# CITY OF ALBUQUERQUE

July 16, 2018  
Alexander Finale Architect  
Yolanda Montoya  
8724 Alameda Park Dr. NE  
Albuquerque, NM

**Re: J-Mar & Associates**  
**85505 Paseo Alameda NE**  
**Traffic Circulation Layout**  
Engineer's/Architect's Stamp 07-14 - 18 (C16-D006DD)

C-1

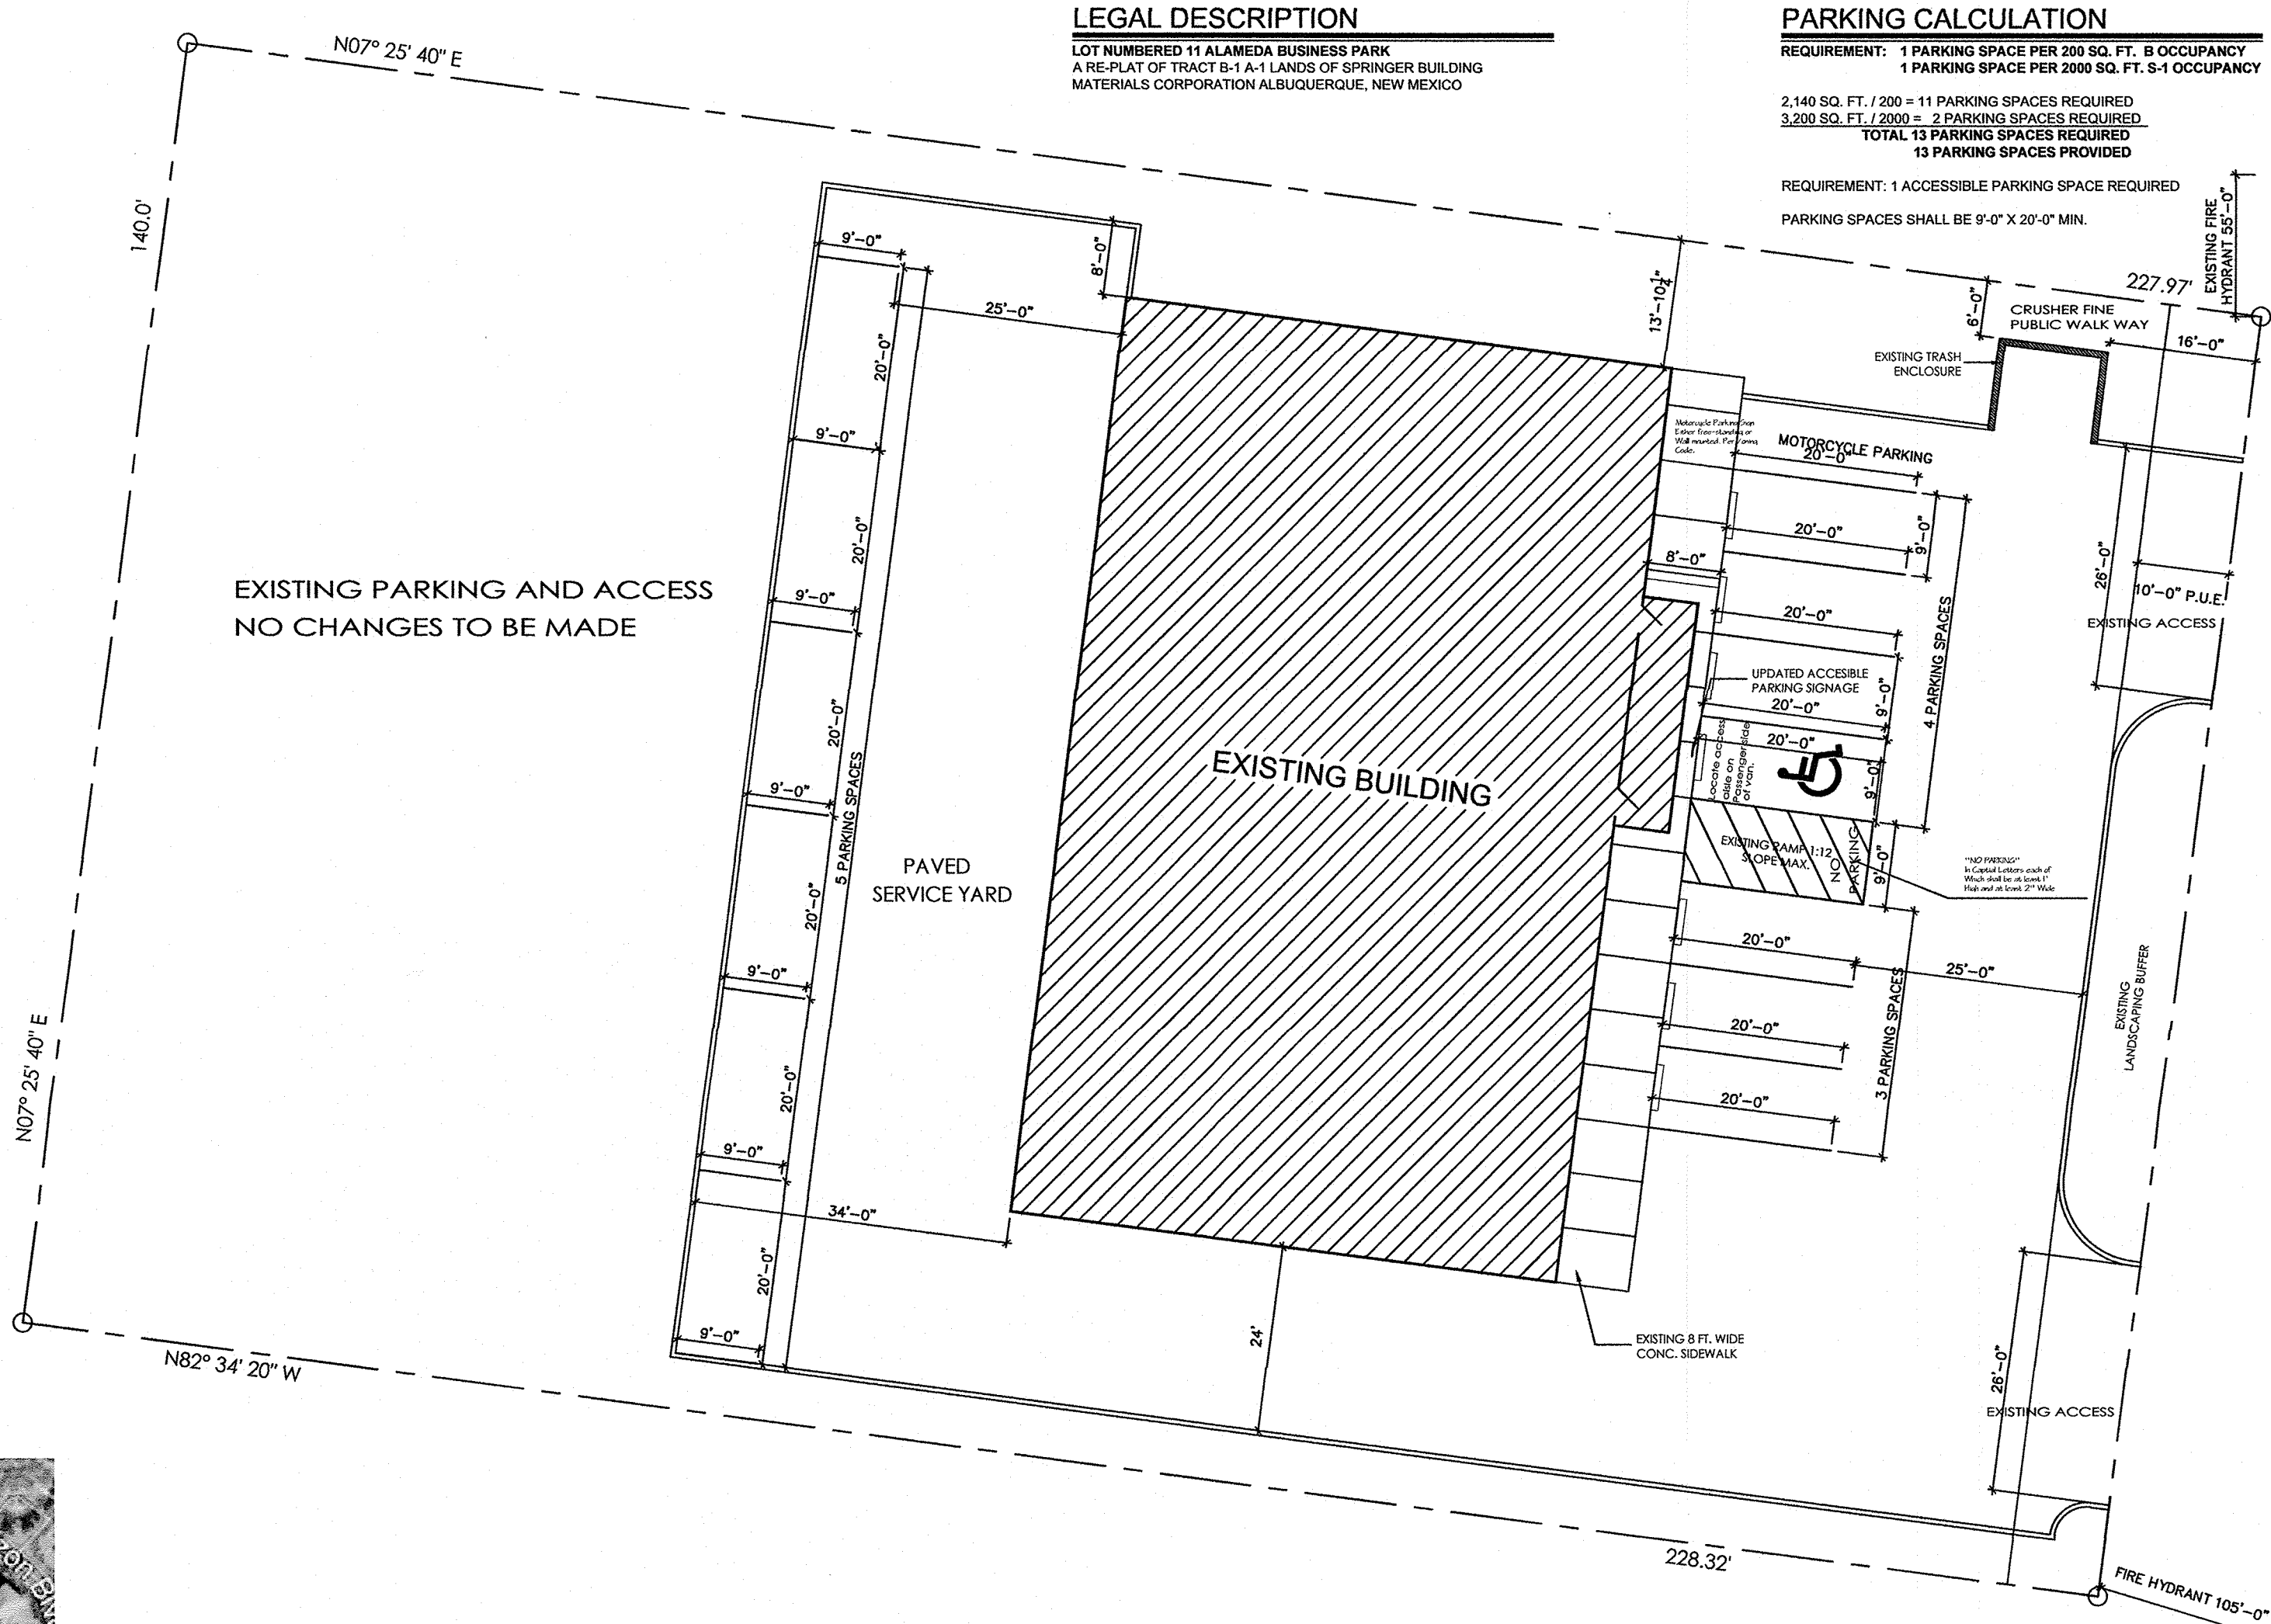
1. Please list the width and length for all existing and proposed parking spaces. Some dimensions are not shown.
2. Please correct the number of parking space provided as shown in the picture below:
